Subject: SP-25-00005 - Transmittal of Comments

Please see the attached correspondence regarding your Short Plat application (SP-25-00005 Hanson). A physical copy of the correspondence has been placed in the mail.

HANSON ROAD SHORT PLAT
 PART OF SECTION 11, T. 17 N., R. 17 E., W.M.
 KITTITAS COUNTY, WASHINGTON

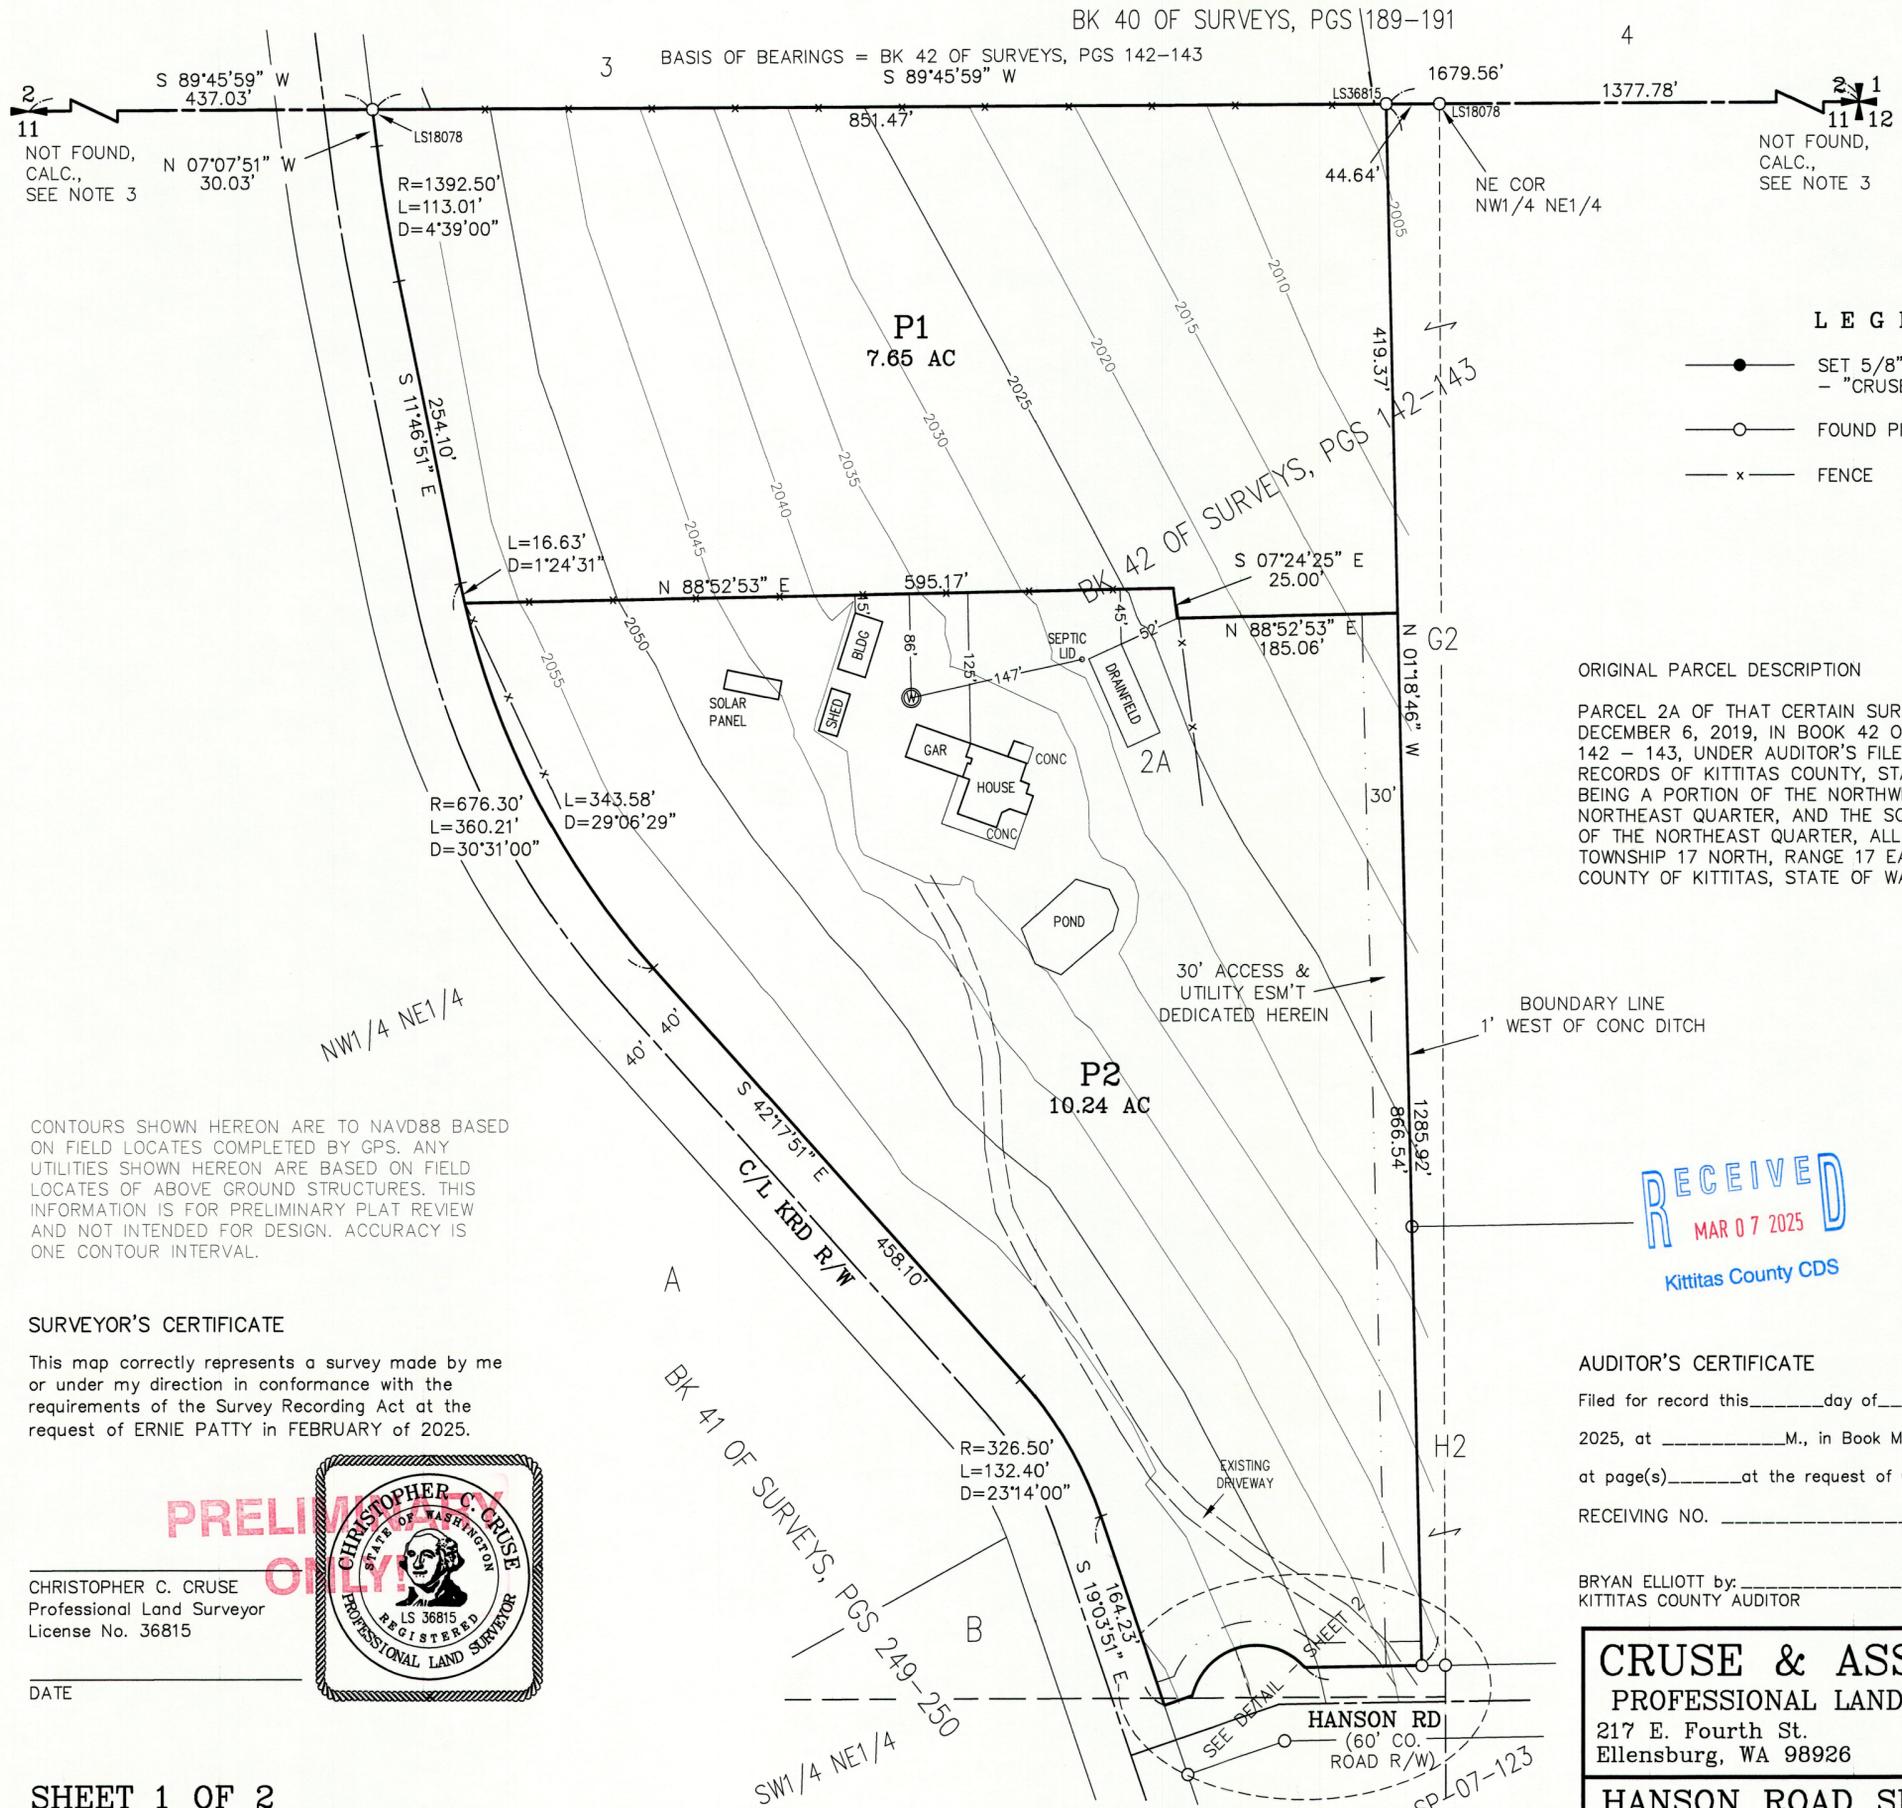
Thank you for the clarification, we would not allow any sewer lines within the 100' radius. You are correct that individual wells require a 5' setback from a building structure or projection and 50' setback from building sewer lines. However, the WAC requires a 100' protection zone in a subdivision with nonpublic wells and our 2-party shared well user agreement example specifically restricts sewer lines within 100' of the well.

Please provide me a more detailed explanation of which specific aspect of the code you have questions about so I can better assist you. The survey does not include a 100' radius on the well. Can you show that the well is provided a water supply protection zone radius of at least 100 feet?

The existing well is 86' from the property line so subsection (ii) would be required. The restrictive covenant can be recorded in the shared well users agreement to meet the requirement of subsection (ii).

Ellie – Ernie and I had a chance to review and hoping we can establish a non-buildable easement to address the required setbacks. The proposed boundary follows the existing fencing and irrigation system for the hay field north of the fence. Jogging the boundary to meet the 25’ setback or shifting the boundary north will affect the existing irrigation. Please review and contact us back with how we can proceed.

I believe Justin meant to reference 17.29.070 Yard requirements - Rear yard. The rear setback is 25 feet, and the structure labeled building on the preliminary plat map shows a 15-foot setback.

Attached is the updated map with 100' setback.

Ellie – Please proceed with the condition we will need to meet the setback for final. We will jog or shift the boundary north 10' to meet the required setback.
